**From:** Samantha Cox  
**Sent:** Tuesday, May 7, 2024 2:06 PM  
**To:** 'Chris Cruse'; Bradley Gasawski  
**Cc:** lhorish@gmail.com  
**Subject:** RE: Comment Period Extension

GRADING PLAN AND STORMWATER MANAGEMENT

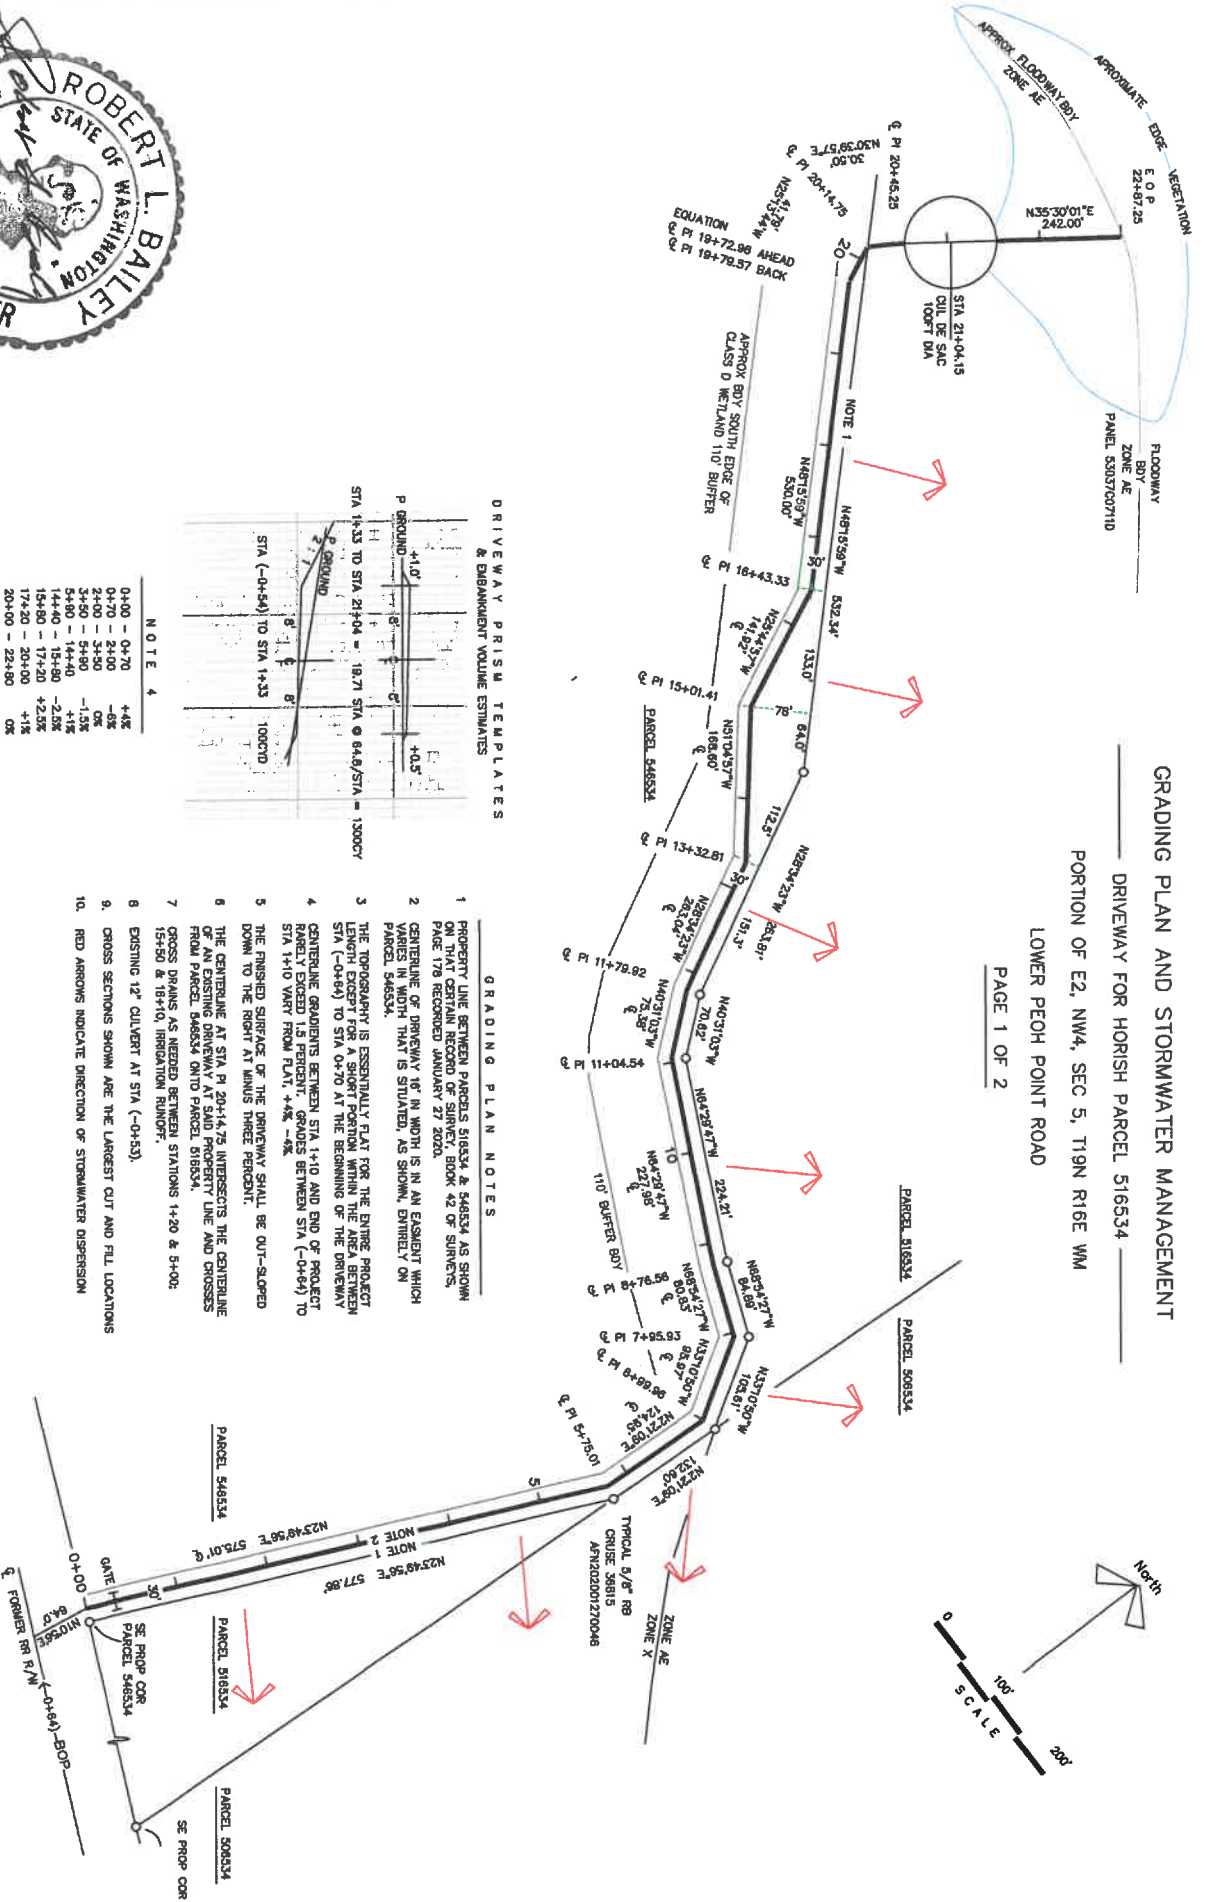
A floodplain development permit can be issued for a driveway in the floodplain if the standards in KCC 14.08.315 are met (see below). It can be difficult to meet these standards in a small area and is advised that development is avoided in the floodplain when possible.

Filling, grading or other activity that would reduce the effective storage volume shall be mitigated by creating compensatory storage on-site, or off-site if legal arrangements can be made, to assure that the effective compensatory storage volume will be preserved over time; provided, however, that no increased upstream or downstream flood hazard shall be created by any fill authorized in the floodplain by this chapter or other applicable chapters.

Bradley - I am working with Linda on her access. Based on my discussion with Linda she may need to move the middle portion of her driveway south out of the 100 year flood zone. We have been involved in a number of flood development permits over the years and don't remember a driveway needing to be adjusted out of the flood zone. Typical driveway construction does not add any fill or volume to the flood zone as the top 8" to 12" of the field will need to be removed as the organic material is not suitable road bed.

We would like to leave the driveway location as is rather than moving it to the south out of the existing easement and farther into the neighbor's property. At some point the driveway will need to enter into the flood zone when it enters the property and to get to the building site. I am including Samantha Cox in this email as I am sure she has seen this issue and may be able to provide us some guidance on how to construct the driveway in the existing easement.
